15 December 2016

The National Trust of Australia (NSW) makes the following comments on the Stage 2 Development Application for tourist and visitor accommodation at the Lands and Education Buildings (SSD 7484).

DRAWING NUMBER **SP-DA-G-2300** ISSUE **013**

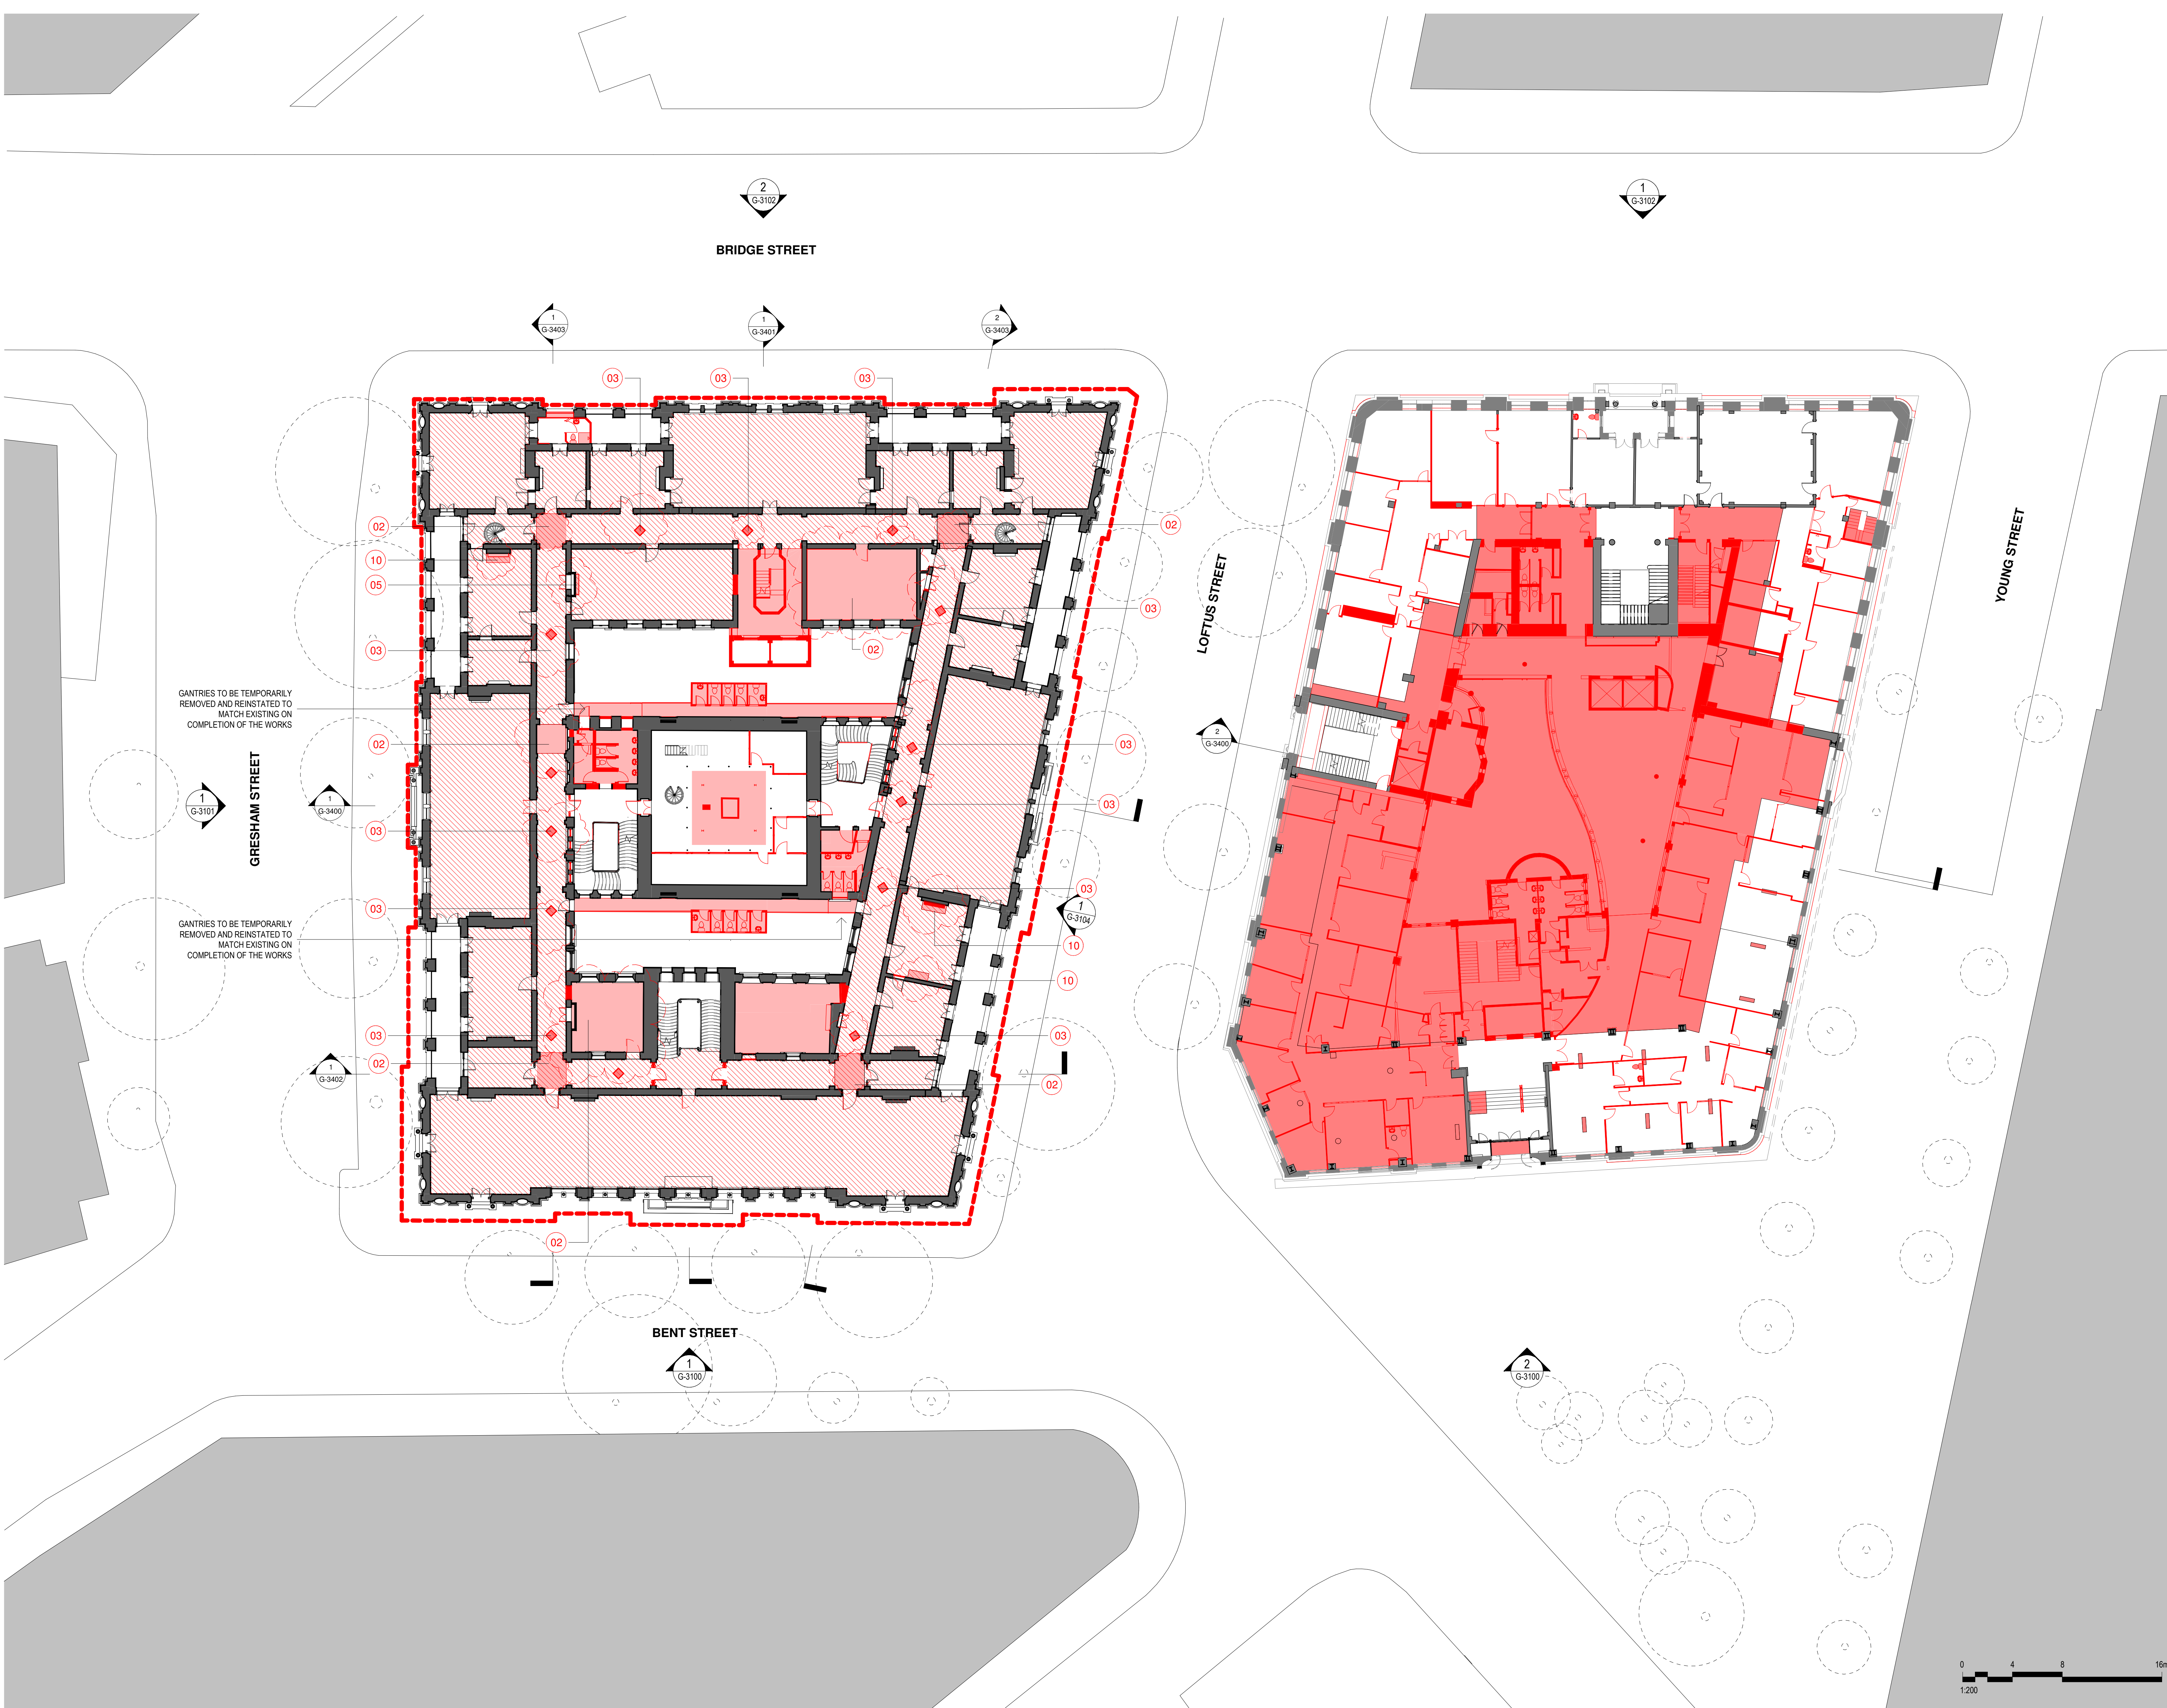
- The National Trust strongly objects to interventions that will adapt the ground level, off Bent Street, as the main hotel guest entry to the Lands Building. The main, historical entry to this building is from Bridge Street, opposite the Obelisk in Macquarie Place from which all distances are measured in NSW - an intrinsic part of the Lands Department Building's significance.

The National Trust strongly objects to interventions that will adapt the ground level, off Bent Street, as the main hotel guest entry to the Lands Building. The main historical entry to this building is from Bridge Street, opposite the Obelisk in Macquarie Place from which all distances are measured in NSW - an intrinsic part of the Lands Department Building’s significance.

The Survey benchmark plug in the Bridge Street entrance will have its significance lessened by removing the main entrance to the building from Bridge Street to Bent Street. With the proximity of Circular Quay and the Opera House to the north, surely retention of a significant public pedestrian entrance to this elevation of the building is acceptable in operational terms for a hotel?

The on-grade Gresham Street loading dock is intended to become the major public entrance to the Lower Ground Level. Utilising a former loading dock and the rear entrance as the main entry points to the building risks the original entry becoming irrelevant. The State Library of NSW suffers from the Mitchell Wing no longer being its main entrance and the same fate should not befall the Lands Department Building.

LANDS BUILDING - ROOF
EDUCATION BUILDING - ROOF

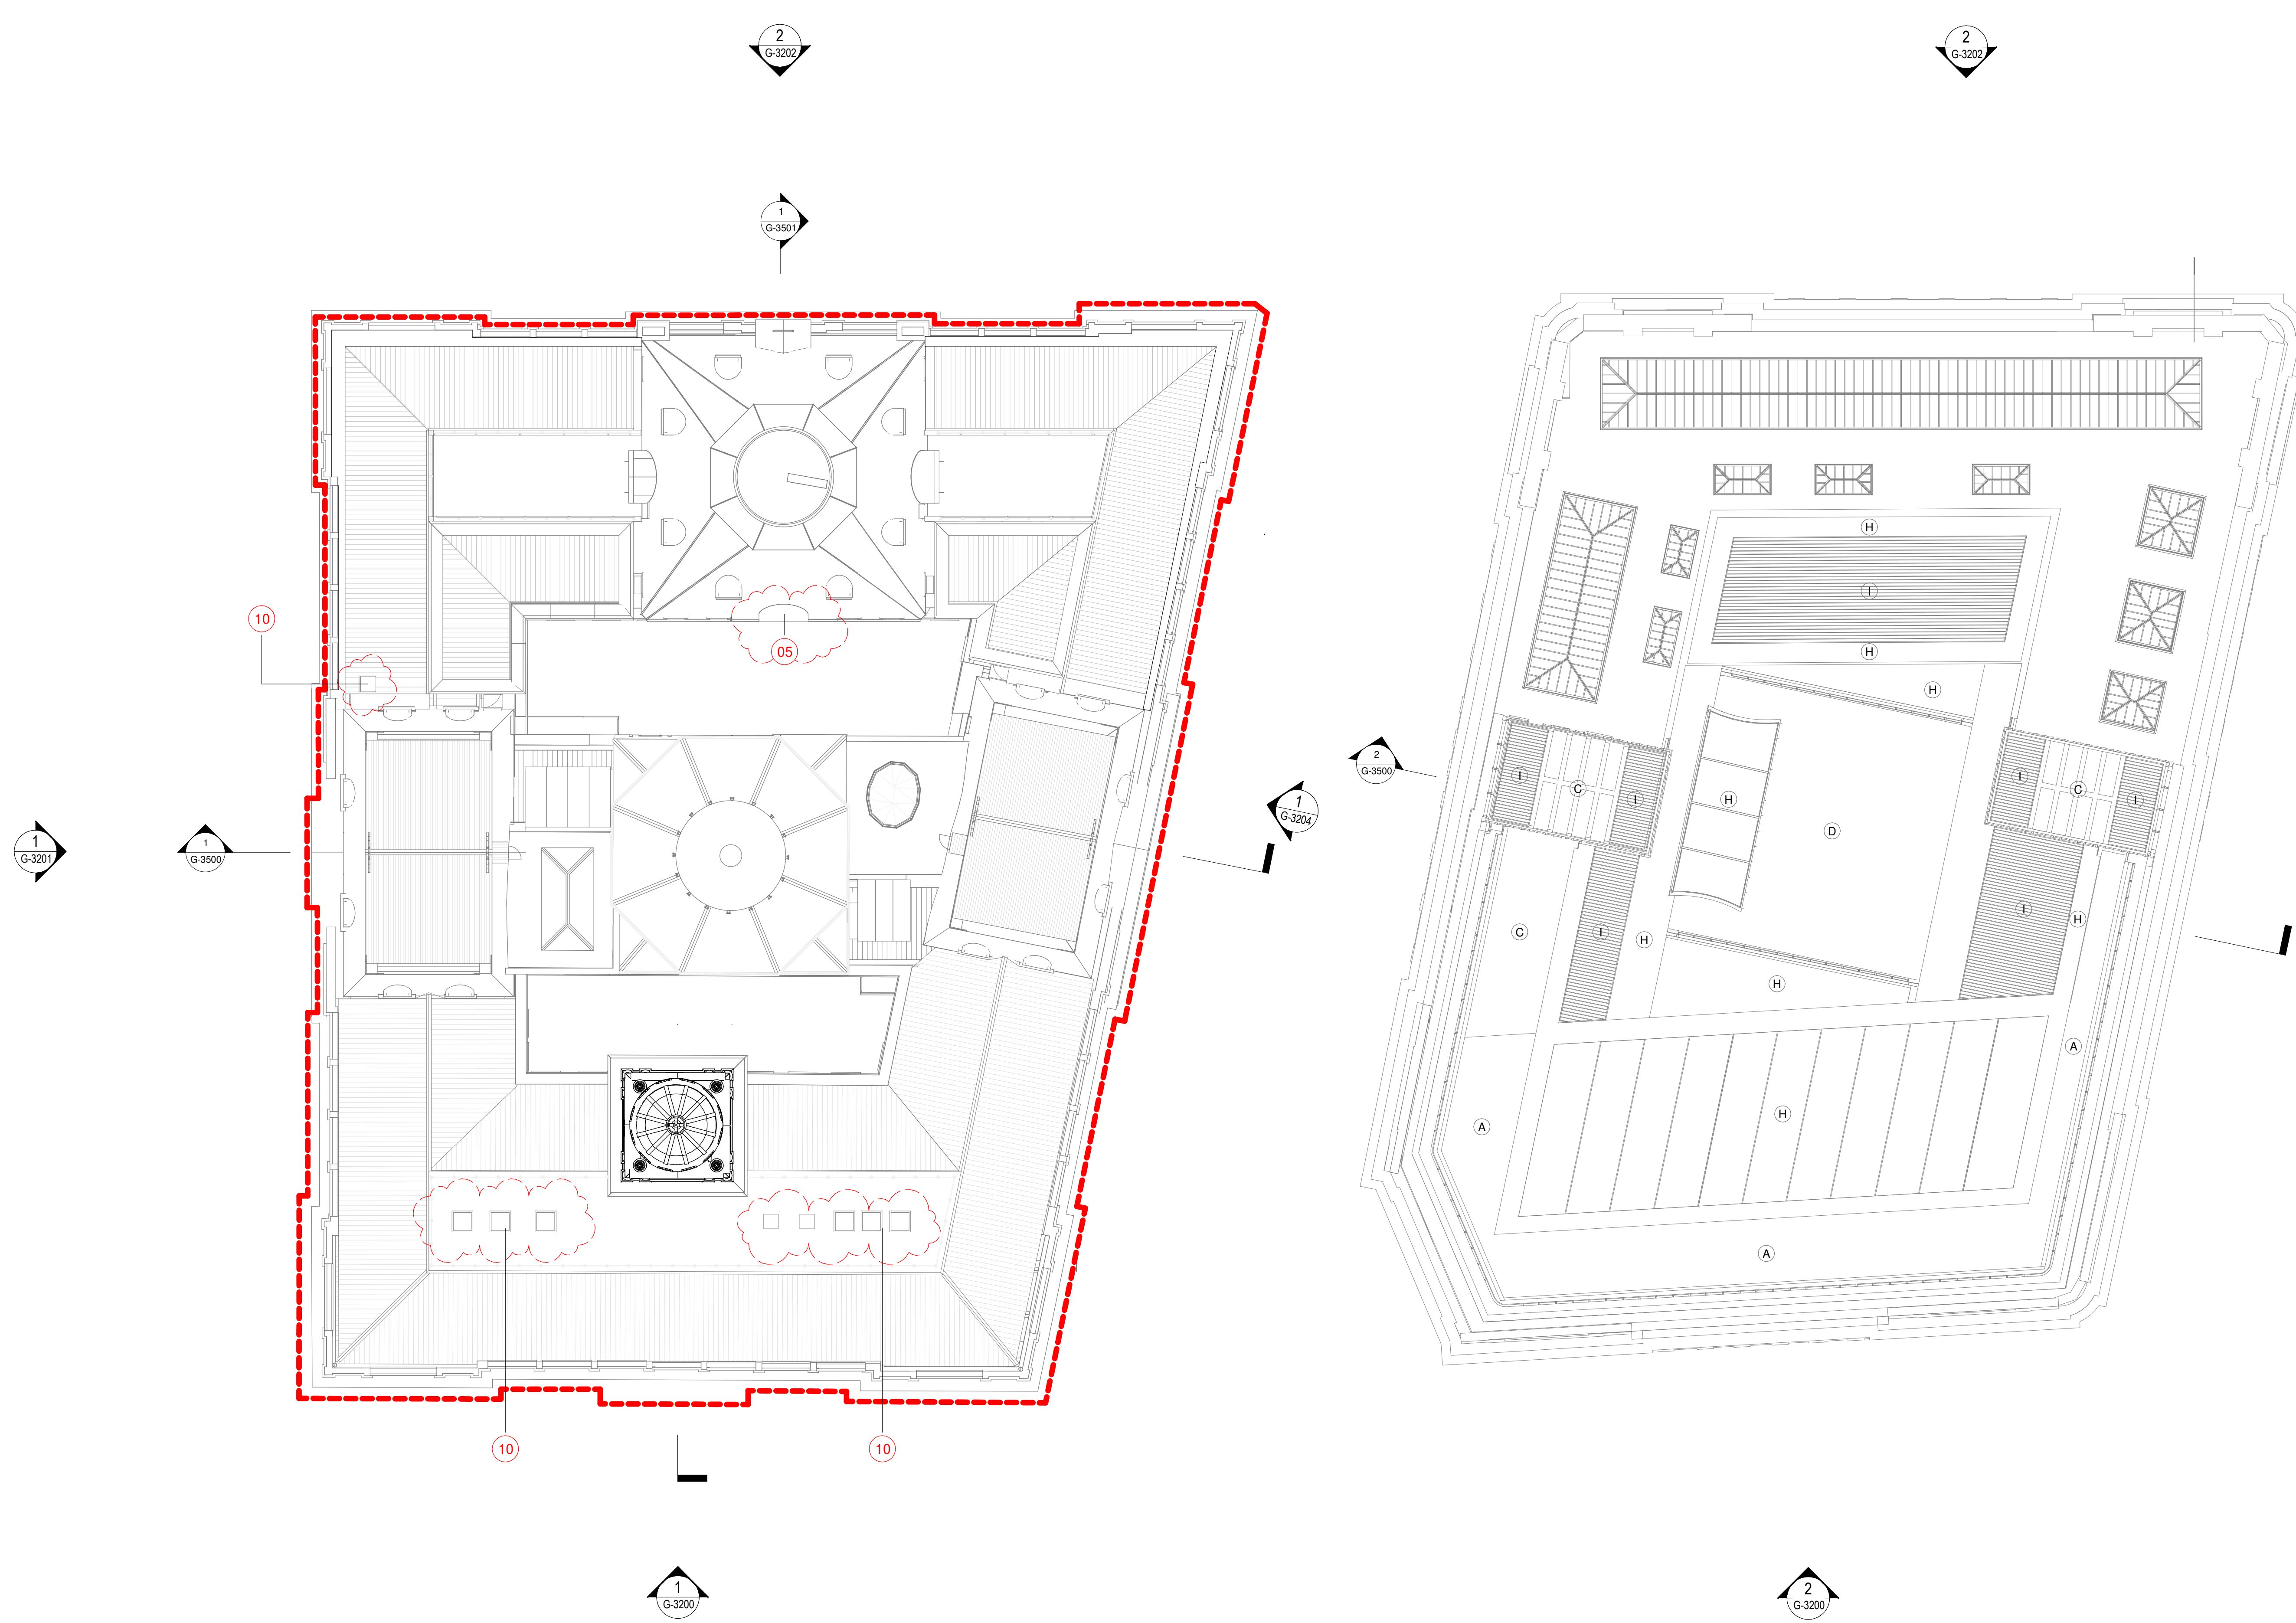
- The Lands Department roofs are an integral part of the building and should be retained. The scheme appears to remove the existing pitched slate roofs and replaces them with another level and a glass roof. This appears to remove a substantial amount of significant original fabric.

The Lands Department roofs are an integral part of the building and should be retained. The proposal might not be highly visible from the ground but the Lands Building is looked down on from many nearby buildings. The scheme appears to remove the existing pitched slate roofs and replaces them with another level and a glass roof - a la Commonwealth Bank (which however had a flat roof). This appears to remove a substantial amount of significant original fabric.

The Heritage Impact Statement (Section 6.3.3) states that “consideration should also be given to reusing or storing representative examples of elements of the iron trusses and all the cast iron roof cresting.” Retention of examples of existing historic roofing elements on-site should be a mandatory condition of any roof redevelopment.
